2 March 2018

Your reference: SSD 8900

**STATE SIGNIFICANT DEVELOPMENT APPLICATION – NULON MOTOR OILS FACILITY
(SSD 17_8900)
BRINGELLY ROAD BUSINESS HUB, LEPPINGTON (PART OF LOT 10 DP 29104)**

DRAWING TITLE
SITE PLAN

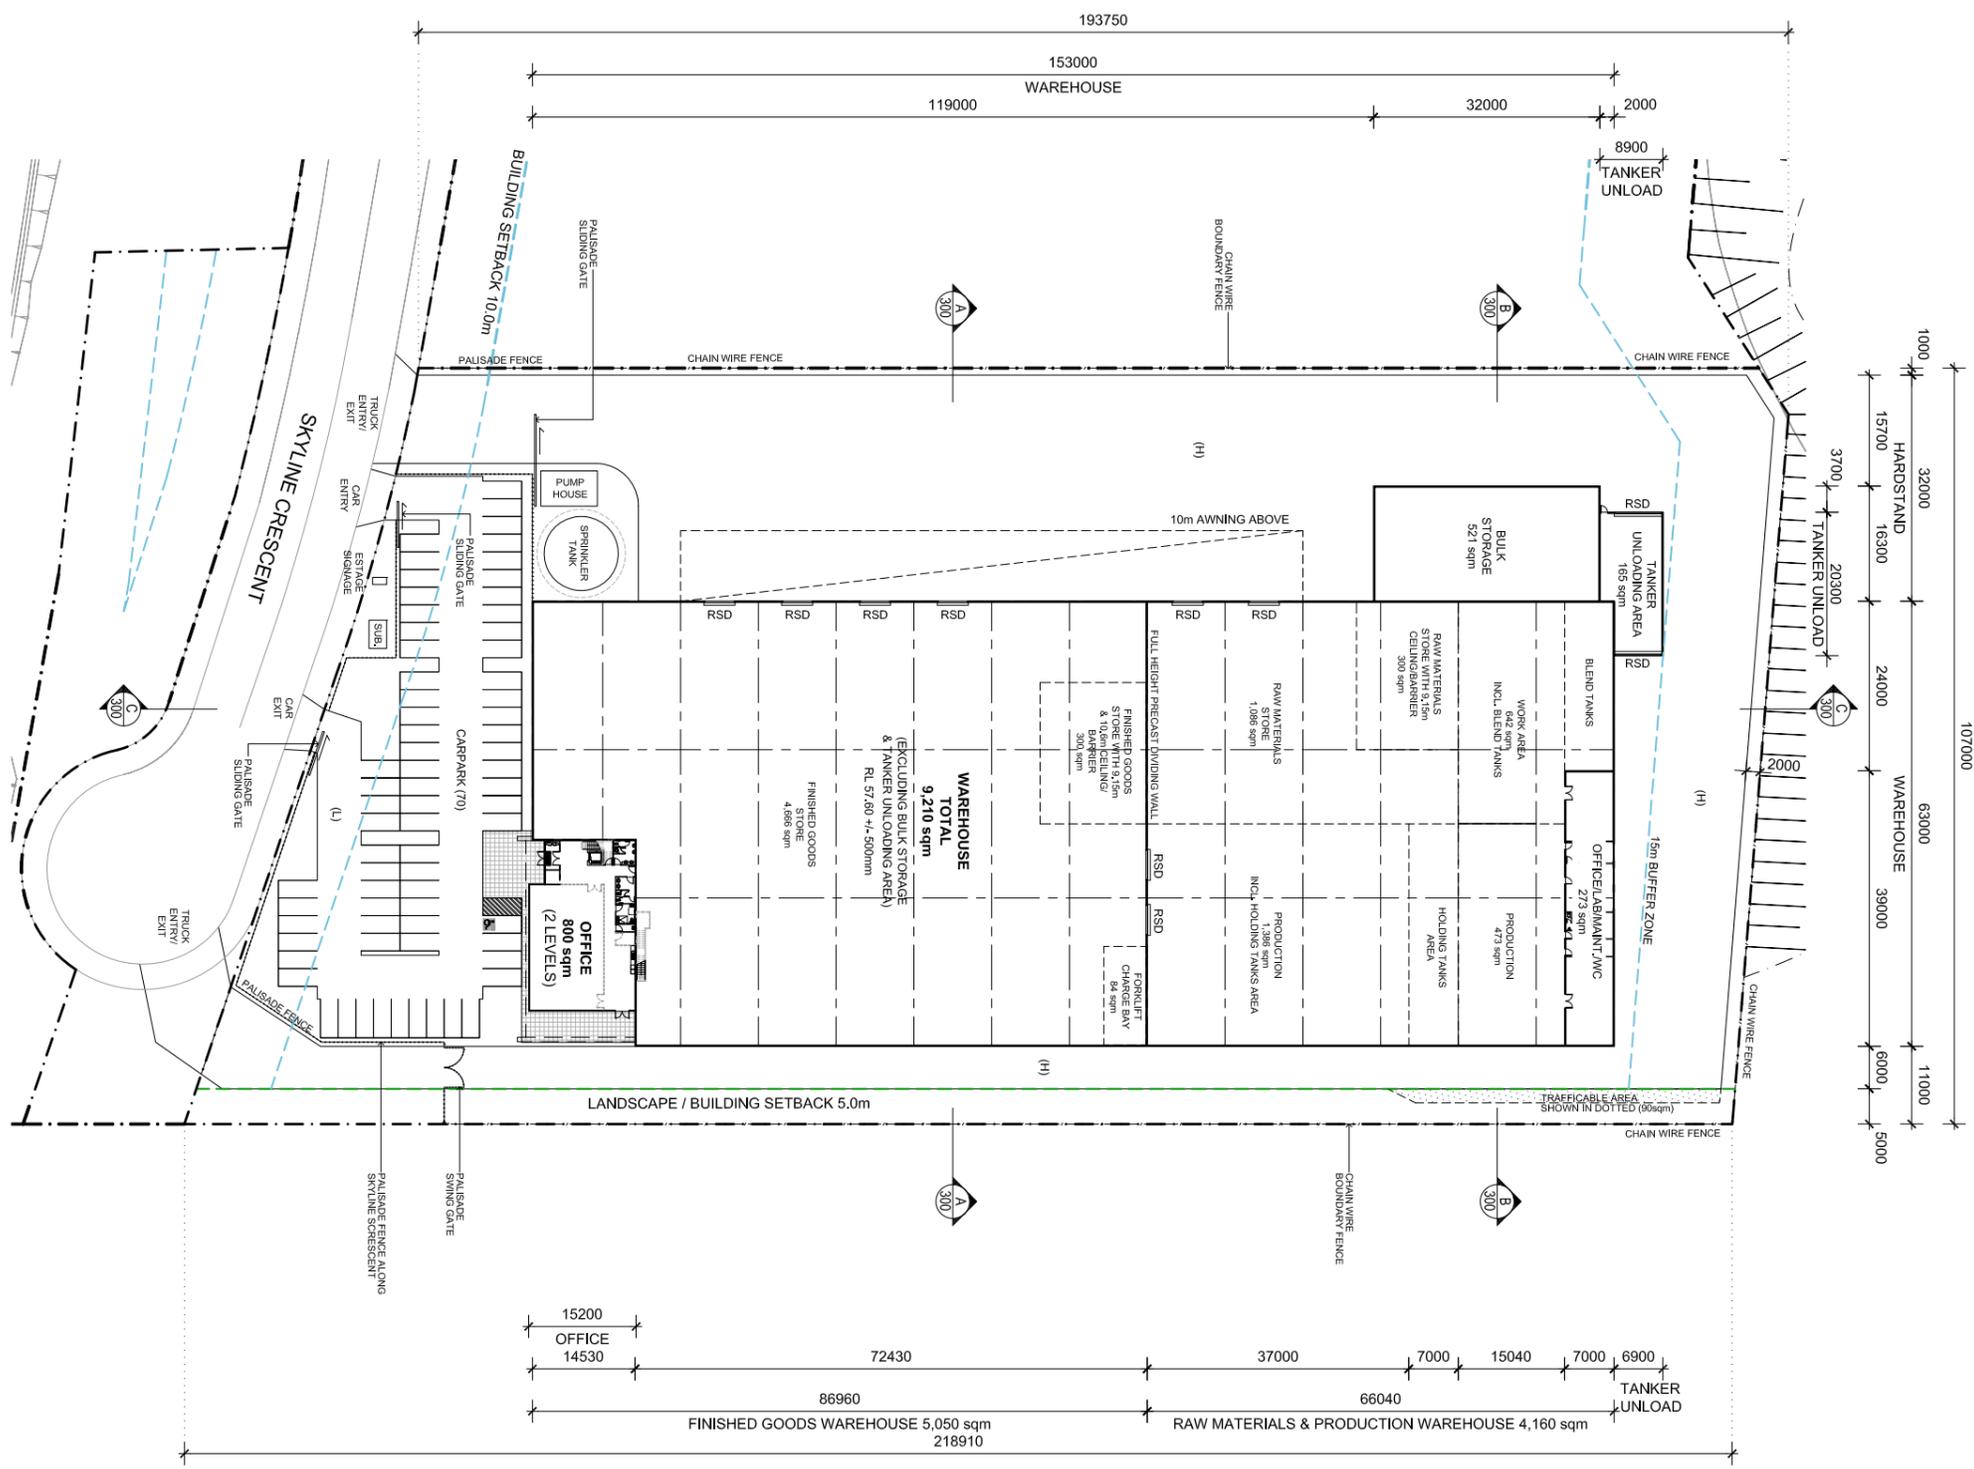
6. The site plan submitted with the application is considered to be poor, lacking basic details and provides no context of surrounding residential properties. It shows the proposal as an island, but the site is adjoined by established residential properties to the east on the opposite side of Cowpasture Road and residential properties to the north. In fact, there is a residential dwelling located to the immediate east of the site on the corner of Cowpasture Road and Bringelly Road. It is highly inappropriate and irresponsible for a State Significant Development industrial development involving the preparation and manufacturing of highly flammable motor oils to have little regard to sensitive land uses surrounding the site.

It is noted that the site is located roughly 200 metres from the residents of Horningsea Park and within 450 metres of the residents of West Hoxton. Within West Hoxton, along Stuart Road is an existing child care centre. It is further noted that the site is situated less than 1.2 kilometres to the east of the Upper Canal Sydney Water drinking water catchment. The Upper Canal is an open canal supplying precious drinking water to the residents of Western Sydney.
